CITY OF ALBUQUERQUE

December 31, 2008

Re: Lucero Development, 313 McKnight Ave NE, Traffic Circulation Layout
Engineer's Stamp dated 11-24-08 (H14-D012)

TRAFFIC CIRCULATION LAYOUT

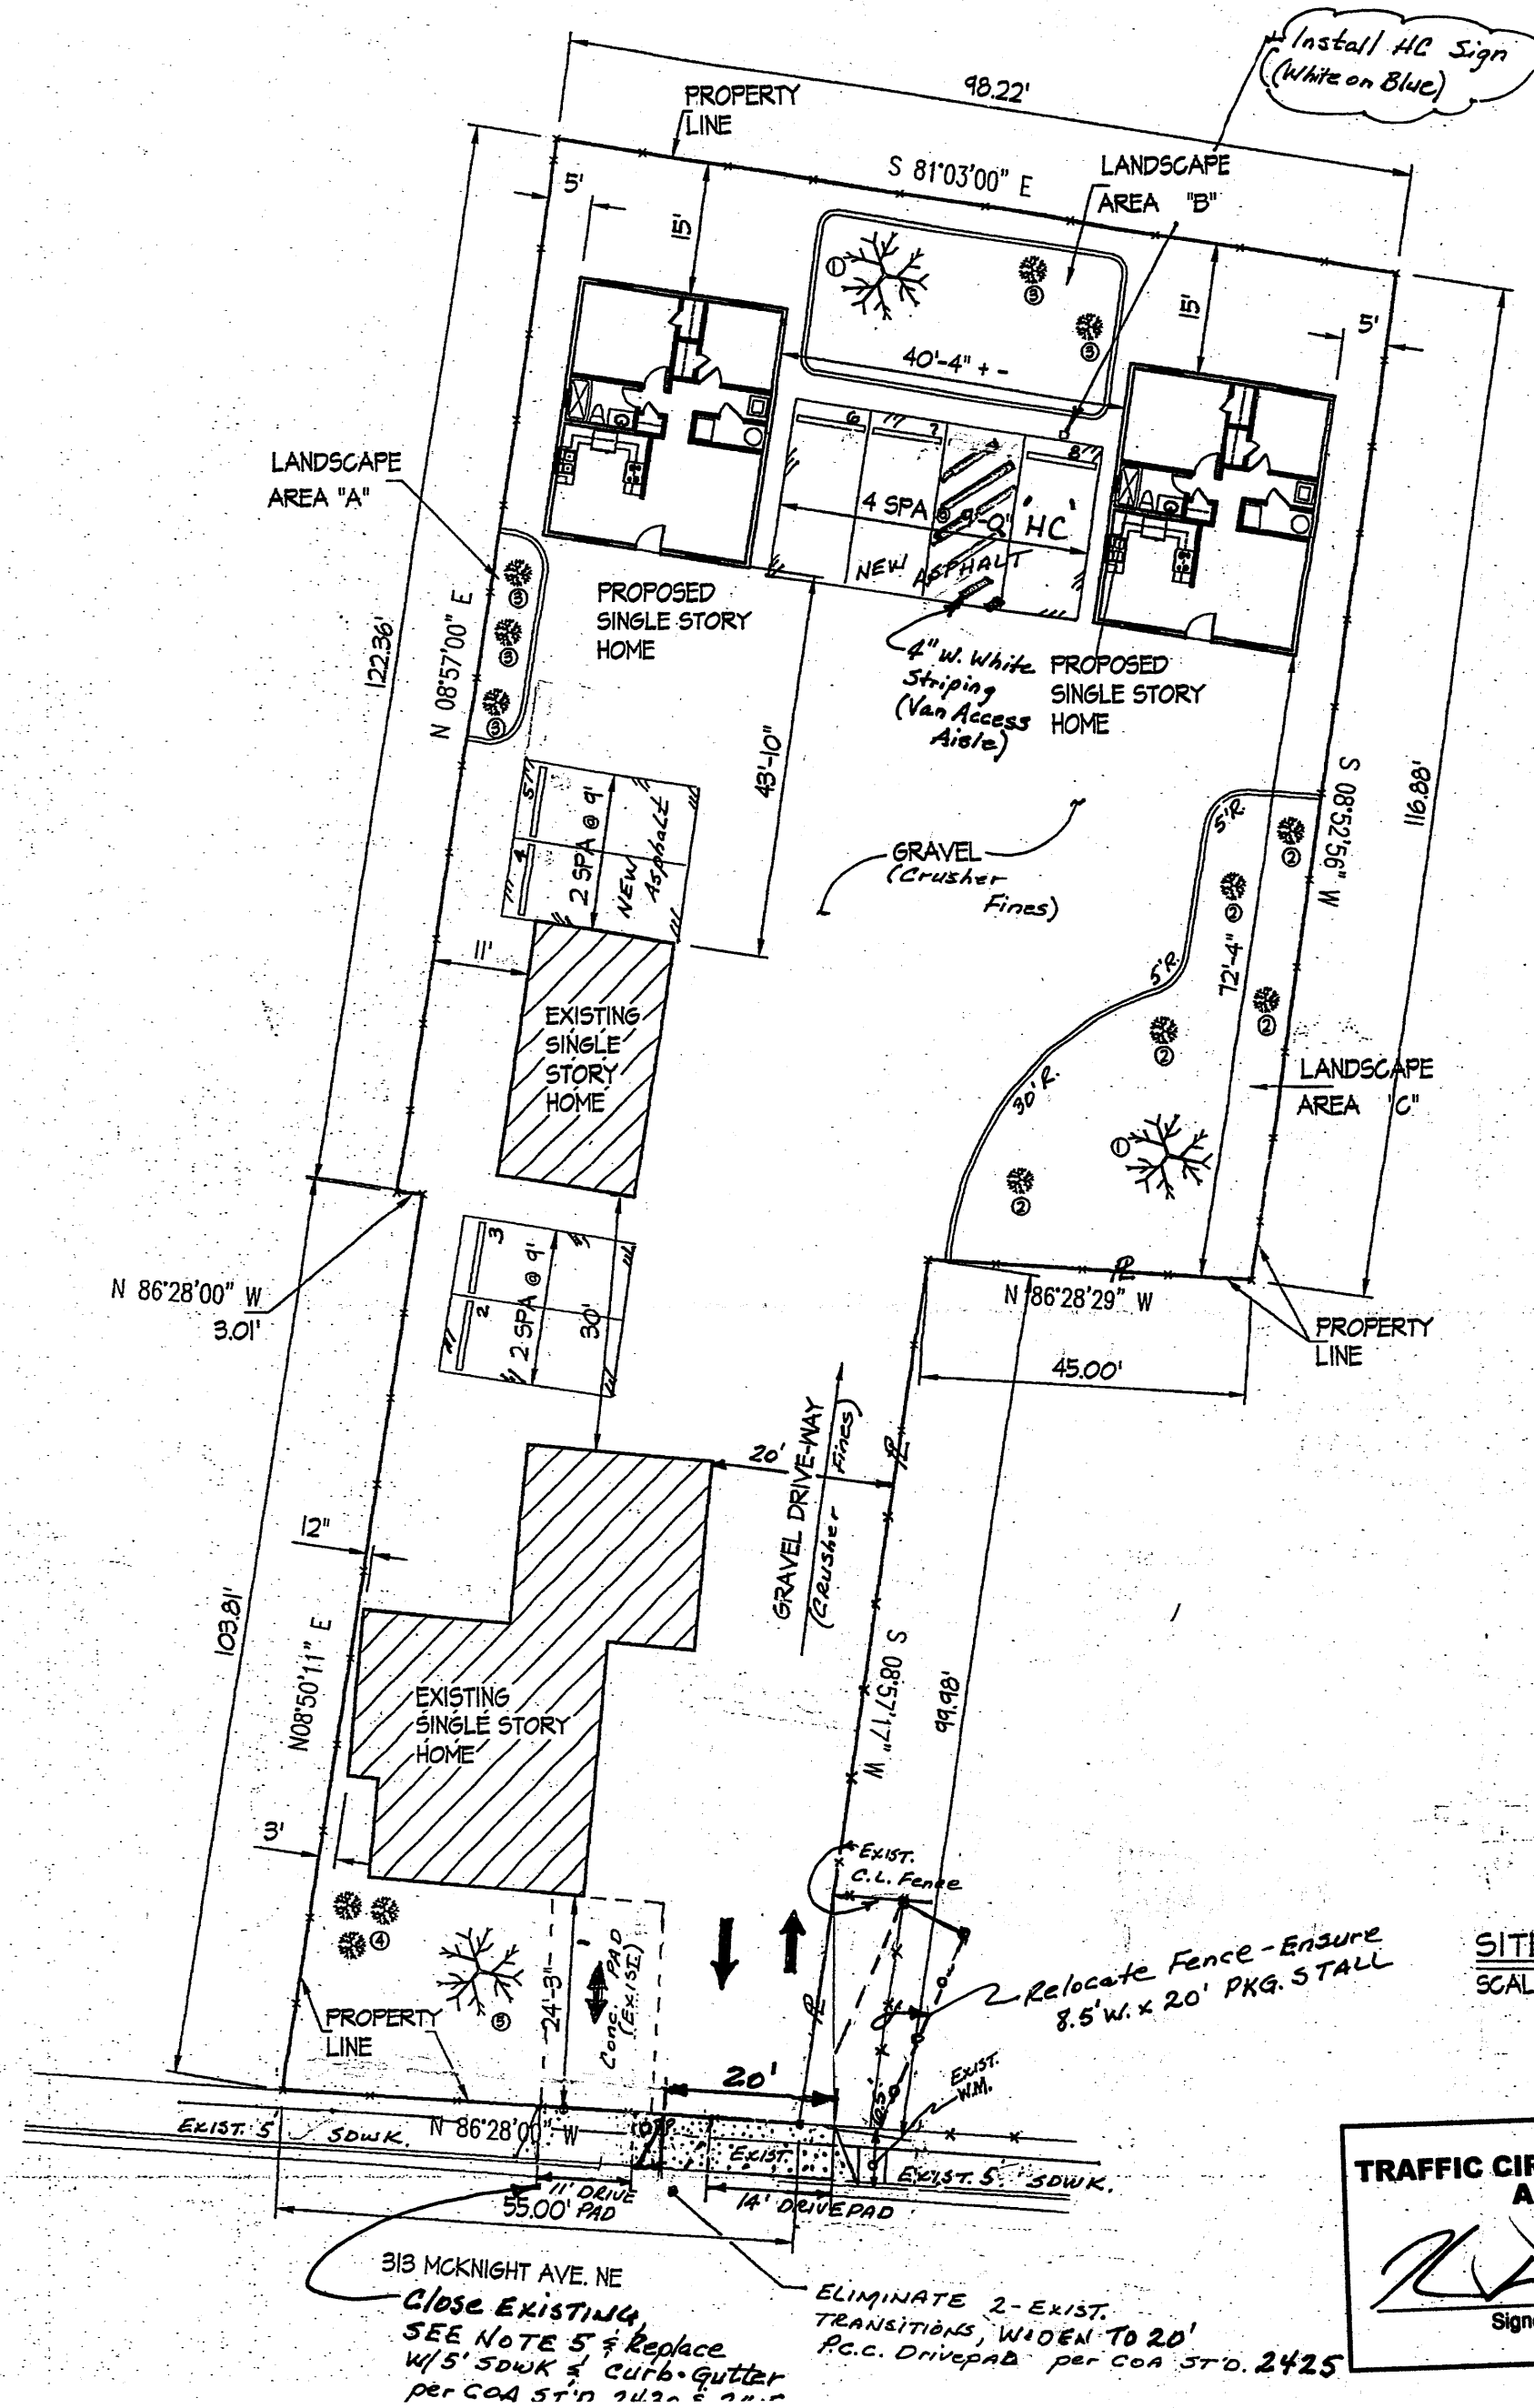
- Keyed note 5 refers to a future common access agreement between the above referenced site and the lot to the east. This easement must be notarized and recorded at this time. Provide a copy for our files.

2. Remove the bumper from the handicapped access aisle.
3. Please show a vicinity map on the plan.
4. Is there any sidewalk located within the site?
5. A build note is needed for the removal of a portion of the existing drive pad ("Remove 11 feet of the existing drivepad, replace with 5 foot wide sidewalk and curb and gutter per City of Albuquerque Standards 2430 and 2415").

6. Keyed note 5 refers to a future common access agreement between the above referenced site and the lot to the east. This easement must be notarized and recorded at this time. A copy of *Figure 23.6.3* of the *Development Process Manual* is included for your reference.

7. Clarify how the lot to the east has access to their lot. Parking along the fence line is not acceptable, as it would block the drivepad.

1. Please show the location of the nearest driveway on the adjacent lot.
2. List the number of parking spaces required by the zoning code as well as the proposed number of parking spaces.
3. The handicapped spaces must include an 8-foot wide van access aisle; all other aisles should be 5 feet in width.
4. Please include two copies of the traffic circulation layout at the next submittal.
5. The drivepad must be a minimum of 25 feet in width for two directional traffic.
6. Please show a vicinity map.
7. The eastern existing drivepad crosses the lot line. Is there a cross lot access easement between these lots?
8. Per the Development Process Manual, Chapter 27, Section 2, Part B.1, only the following scales may be used:
 - 1" = 50'
 - 1" = 40'
 - 1" = 20'
 - 1" = 10'
 - 1" = 100' (for overall layouts only)
